Ribble Valley Borough Council
Housing & Development Control

Application no: **3/2022/0166**

Address: **Queen Mary Terrace and Bridge Terrace Mitton Road Whalley BB7 9JS**

Proposal: **Discharge of conditions 4 (Highways), 8 (CEMP), 11 (Drainage) and 12 (Drainage verification) of application 3/2021/0076**

- Construction Management Plan

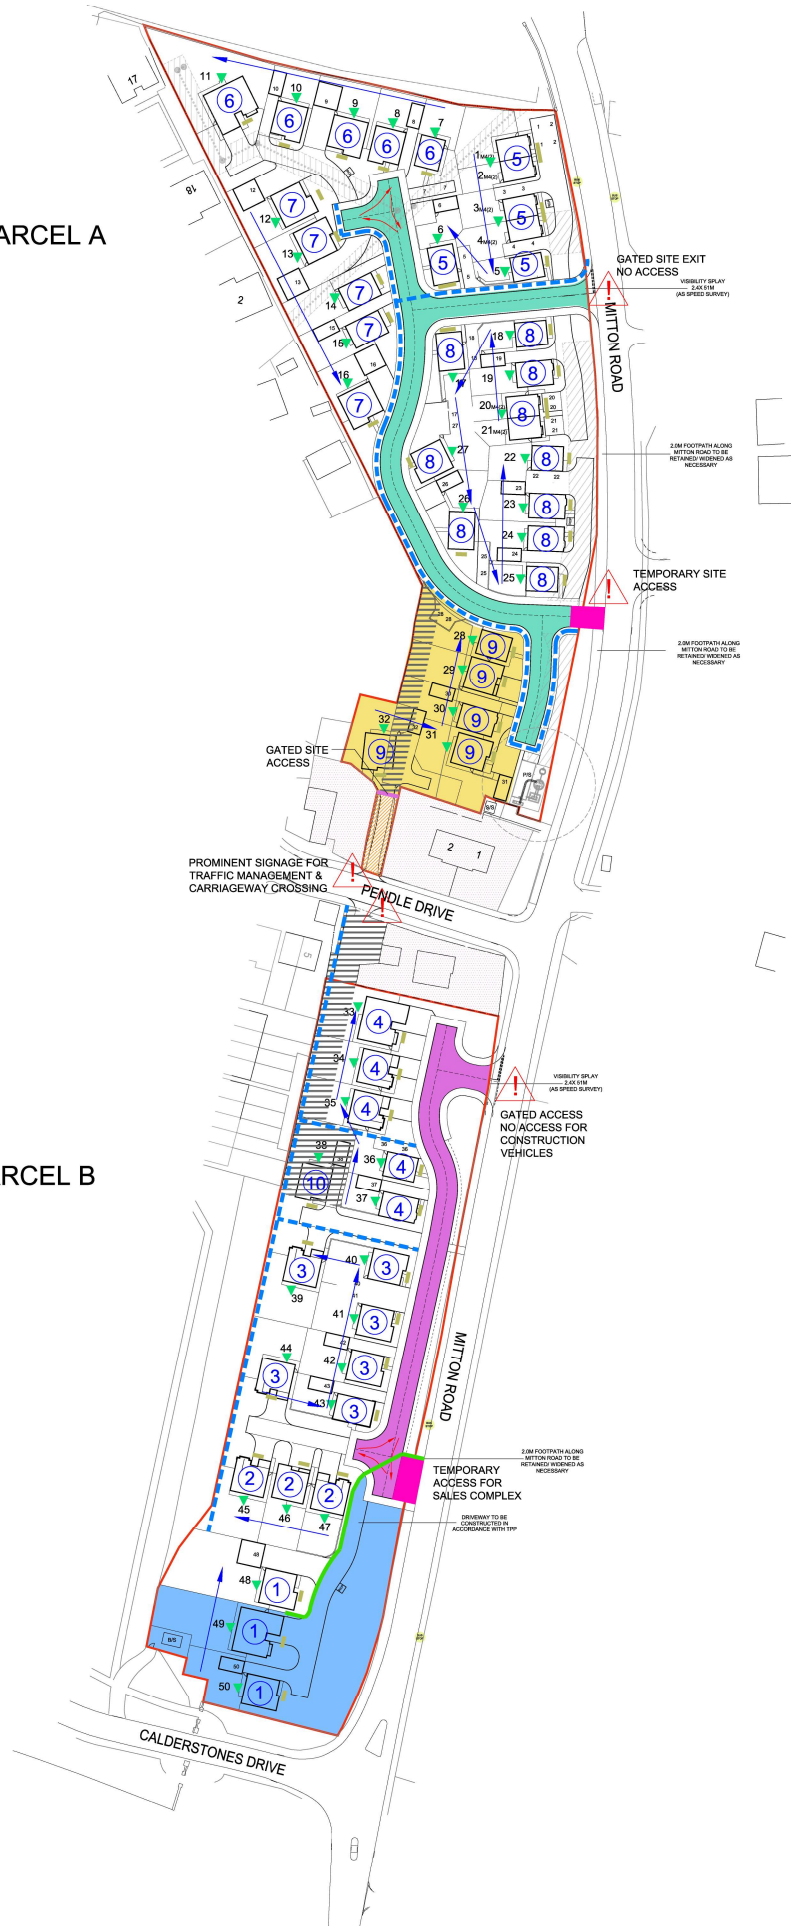
However, the LHA have reviewed Prospect Homes drawing number CMP-01 Rev C titled "Construction Management Plan" and are unable to support the creation of the temporary access for Parcel One. This is because the proposed temporary access is overlooking the existing commercial access serving Mitton Road Business Park, which the LHA have concerns about.

The LHA are also unsure about the need to create a temporary access to serve Parcel One. This is because, as stated in the Construction Management Plan, all deliveries are going to be controlled and by appointment only. Therefore, the LHA are not convinced about the need for a temporary access in this location and request that the existing access is used for all visitors, in and out of the site.

Furthermore, the LHA are aware that one of the justifications to create a temporary access during construction is so that the two accesses can be used in an "in, out only formation." However, should the developer have concerns regarding not being able to exit the site in a forward gear for deliveries, an internal turning area should be provided to ensure this occurs.

The LHA are aware that there is an access to the compound area from Pendle Drive. However, the LHA are unable to support the creation of the access located off Pendle Drive due to the residential nature of the road and request that this link is removed from the plan.

The LHA are also concerned that the link located off Pendle Drive, will be used to serve Parcel 2 with raw materials from the compound transported from this area. However, to prevent the need to transport materials from Parcel 1 to 2, the LHA require a small, compound area to be erected at Parcel 2.

The LHA have further reviewed Prospect Homes drawing number CMP-01 Rev C and require the proposed temporary access serving Parcel 2 can provide the minimum visibility of 2.4m x 51m in both directions. This is to ensure that the minimum visibility is provided which was agreed following the speed survey being accepted under application reference 3/2021/0076.

The LHA also require that Parcel 2 provides a parking area for visitors to the Sales Complex to use. This is because the LHA want to prevent inappropriate parking associated to the development from occurring.
